Mangoola Coal Continued Operations Project (MCCOP (SSD-8642)): Environmental Assessment – Response to Submissions

I refer to correspondence dated 19 December 2019 inviting the Resources Regulator to provide advice on the Mangoola Coal Continued Operations Project - Response to Submissions for Mangoola Coal Continued Operations Project MCCOP (SSD-8642).

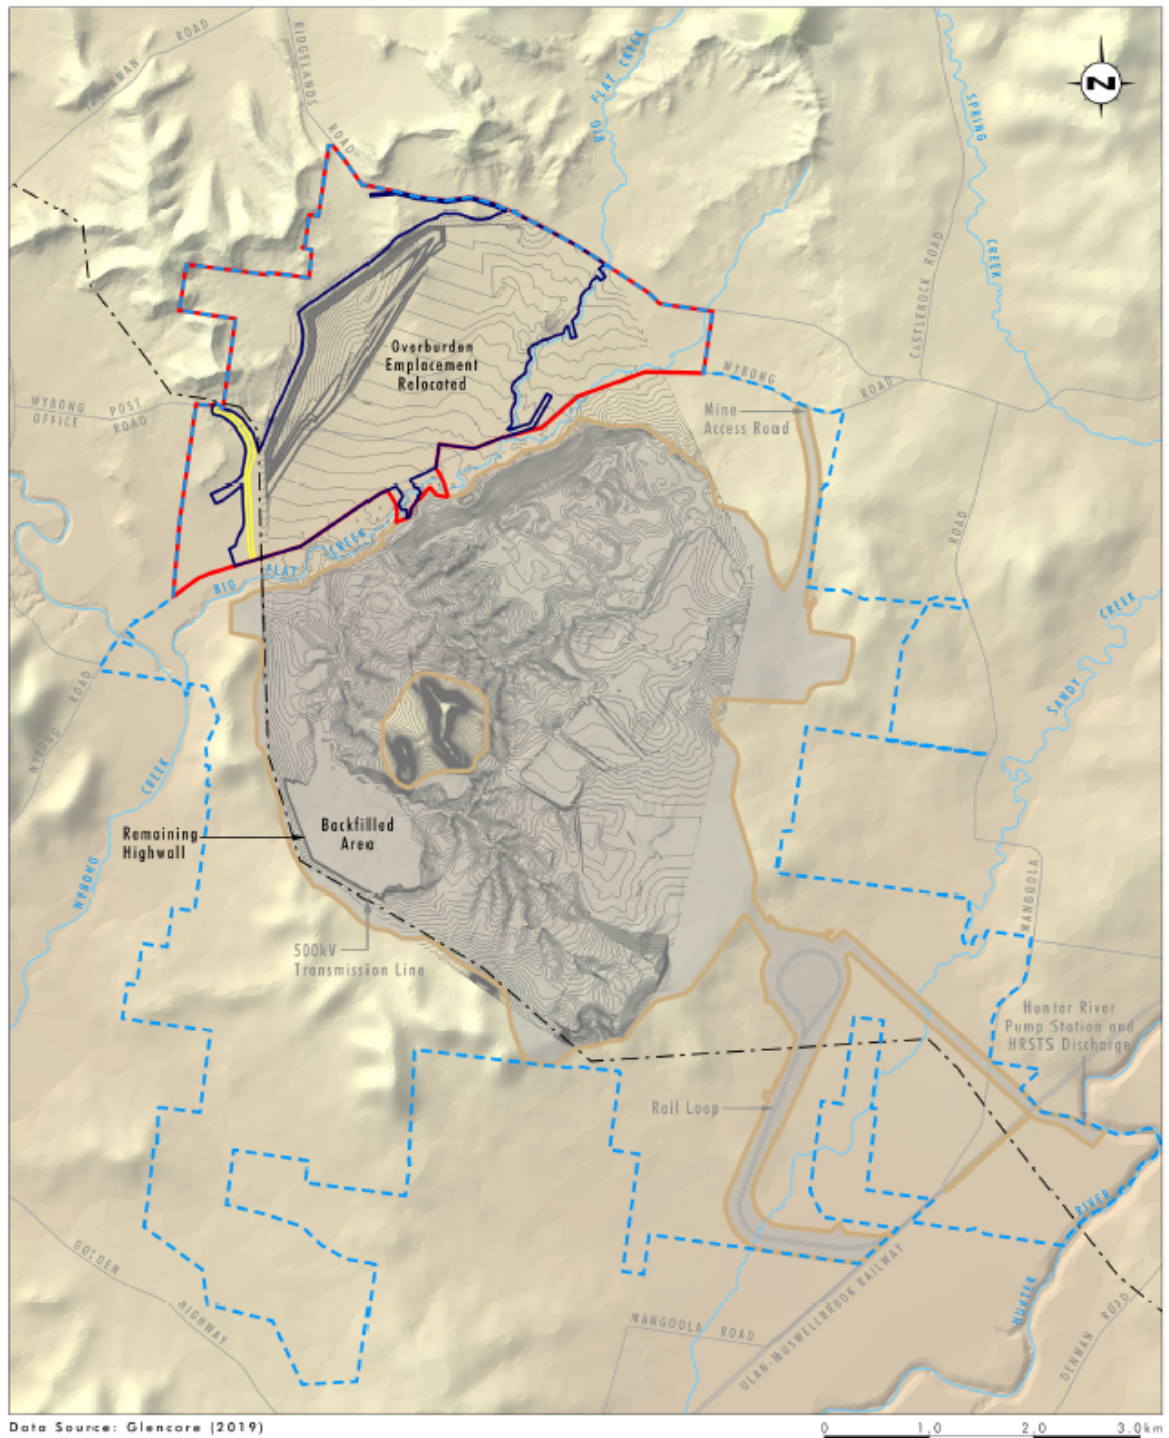
- The level of detail provided in the Environmental Impact Statement and Response to Submissions is not consistent between each considered final landform. The independent review has considered economic, mine feasibility / engineering and broad environmental outcomes to further justify the preferred final landform (case 3). The financial implications and surface disturbance area of each option has broadly been described. The Resources Regulator does not consider sufficient information has been provided to discount differing case options. For example, case option 6 (partial backfilling of each void) has been cited as resulting in a larger surface area affected by the final void, however whether sustainable rehabilitation outcomes may have been increased / decreased such as increased land use opportunities and potentially enhanced landform/ geotechnical stability have not been articulated for each discounted option. As such, the Resources Regulator cannot comment on the appropriateness of the preferred final landform. The Resources Regulator would recommend that at minimum, further information is provided for landform case option 6 (partial backfilling of each void) and case option 4 (one final void in the north).
